Application number: 2026/92450	
What is the application for?:	Demolition of existing workshop and erection of detached dwelling
Address of the site or building:	Workshop between, 12 & 14/16, Temple Street, Lindley, Huddersfield, HD3 3JG
Postcode:	HD4 6HF

Type of comment: An objection	
Do you wish your comments to be published on the website anonymously?	Yes

- Materials
- ① Reclaimed natural walling stone.
 - ② Through coloured rendered wall finish.
 - ③ Blue slate roof.
 - ④ Grey windows with natural stone heads, cills and mullions.
 - ⑤ Grey doors.
 - ⑥ Black rain water goods.
 - ⑦ Grey framed rooflights.
 - ⑧ Inset Solar Panel.

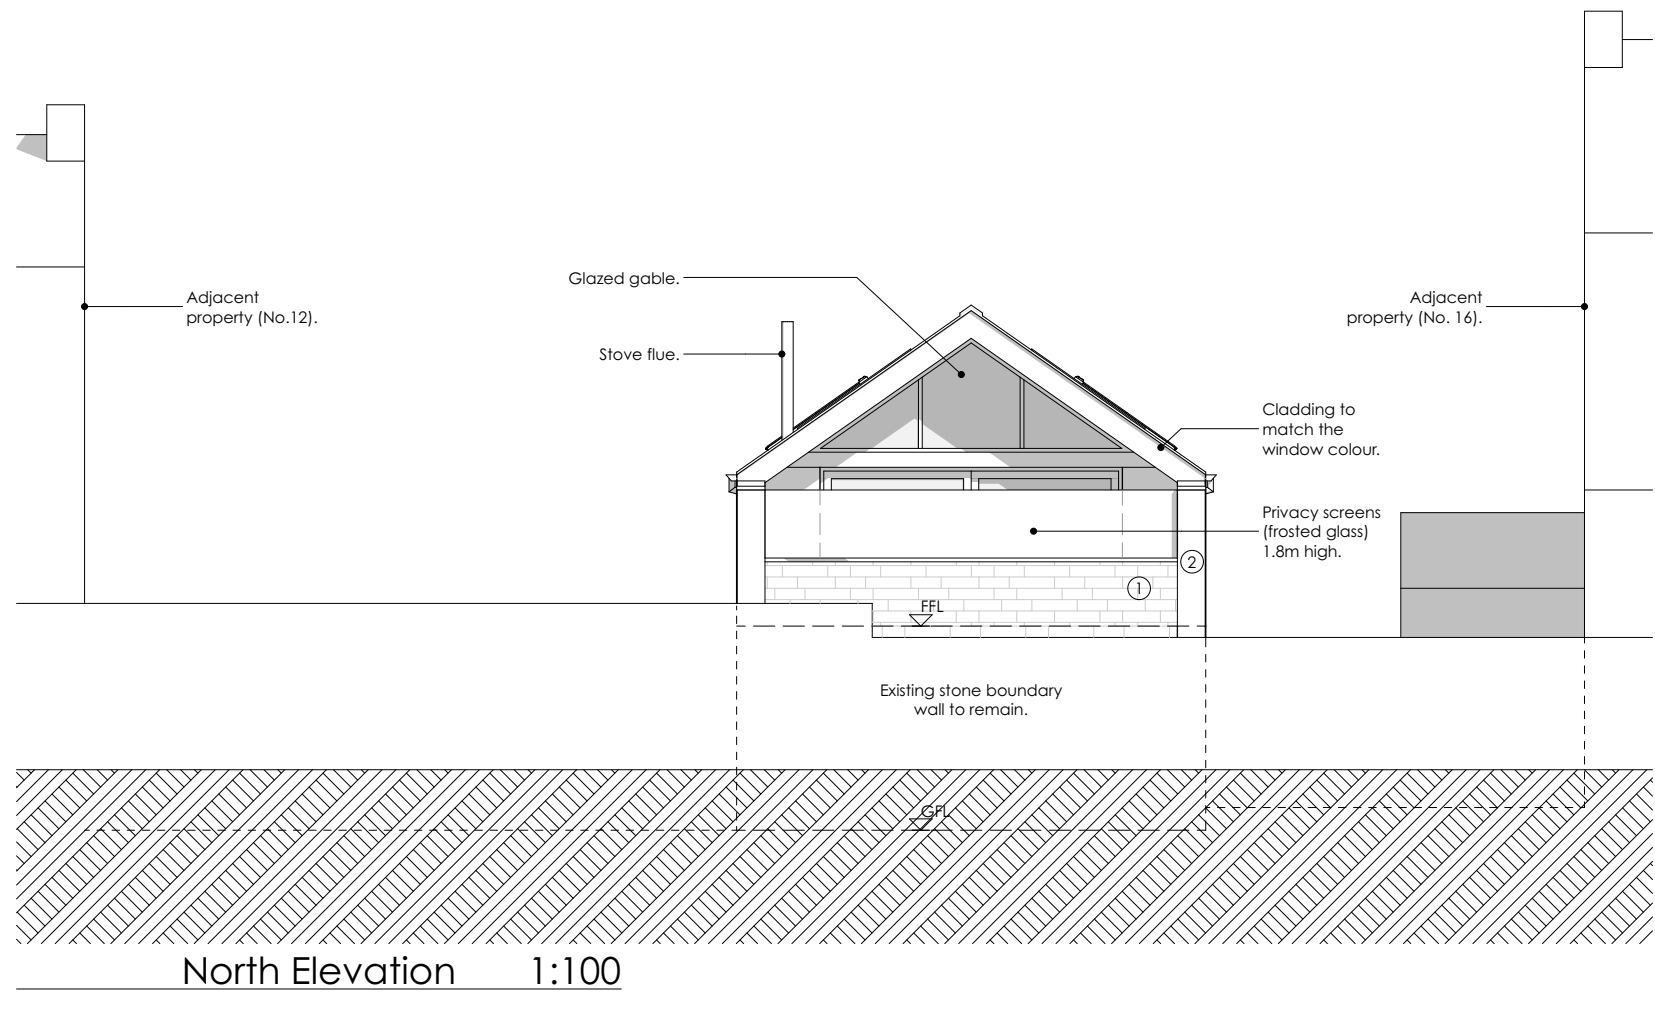
I strongly object to the inclusion of a ground-floor bedroom windows positioned . While I note the window is intended to be frosted glass with a 1.7m FFL inward-opening top vent, the fact that this window serves a primary habitable room (a bedroom) violates standard planning policies regarding residential amenity and design layout. I request that the planning department refuses permission or enforces a mandatory redesign of the building layout based on the following material planning considerations:
Loss of Privacy and Unacceptable Impact on Residential Amenity

Noise, Nuisance, and Loss of Quiet Enjoyment via
the Opening Vent

This layout creates an unacceptable reciprocal noise nuisance that cannot be mitigated by obscure glass. Conflicts between Ventilation Requirements (Part F) and Fire Safety (Part B)

this design creates an irreconcilable conflict with UK Building Regulations: Under Building Regulations Part B (Fire Safety), an opening window or "unprotected area" directly presents an unacceptable risk of fire spread and is strictly limited or prohibited. To comply, windows typically must be non-opening and fire-rated. However, under Building Regulations Part F (Ventilation), a bedroom requires an openable window area or adequate purge ventilation. Because the window cannot be safely conditioned to be fixed shut without depriving the habitable room of required ventilation, the current design is fundamentally unworkable. The window must be entirely omitted from this boundary elevation and the room redesigned with an alternative layout or outlook.
Conclusion & Requested Action.
